Application no: H18/0156/09

Description: Proposed new workshop and alterations to
vehicular access

Location: Hospital Workshop
Hospital Road
Wingland

Amendment: Increase width of access by 2 metres

Scales : 1:50, 1:100.

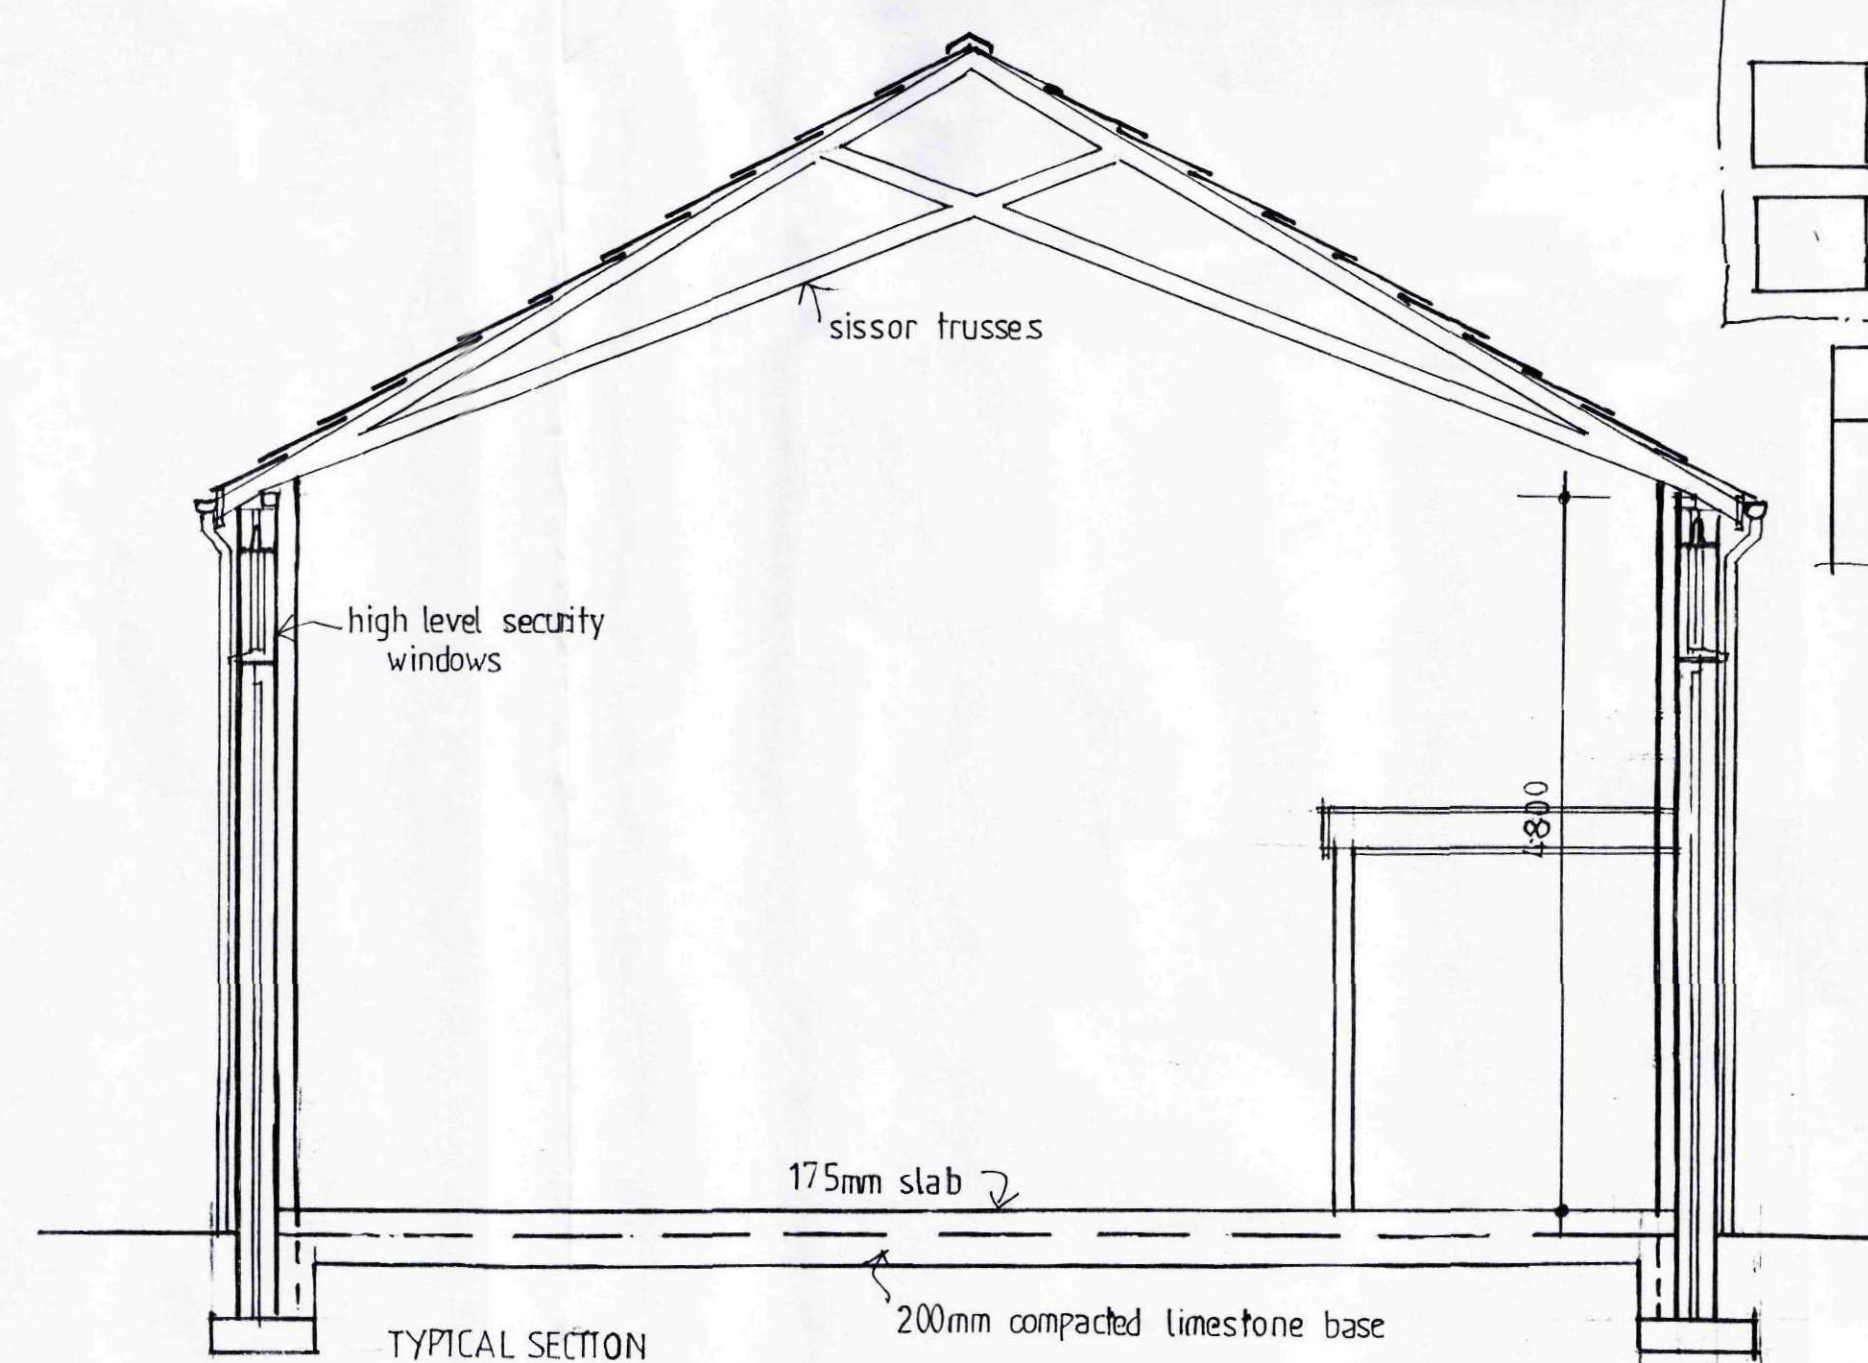
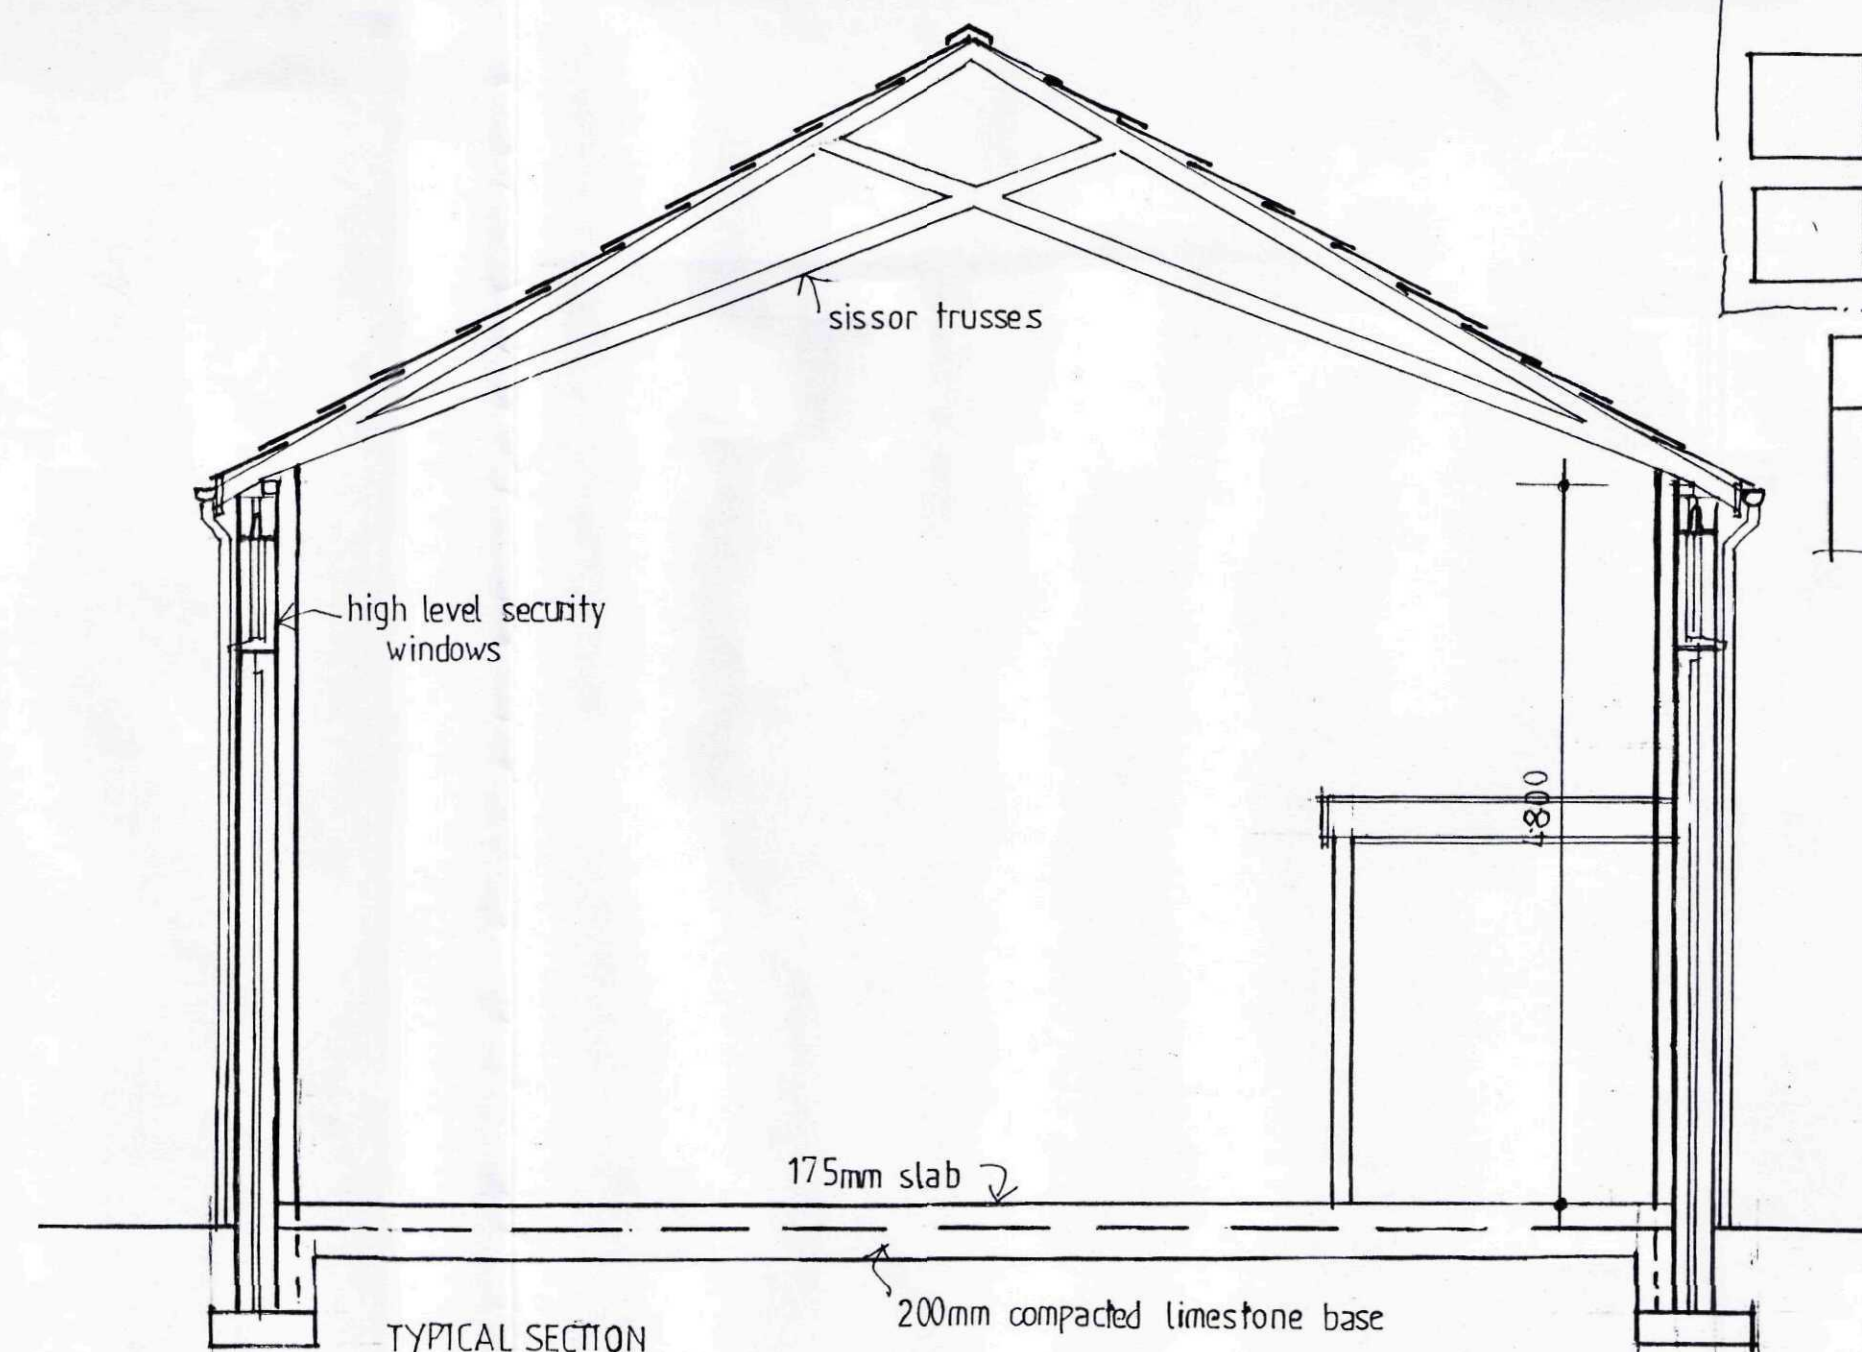
Description Increase width of access by 2m.
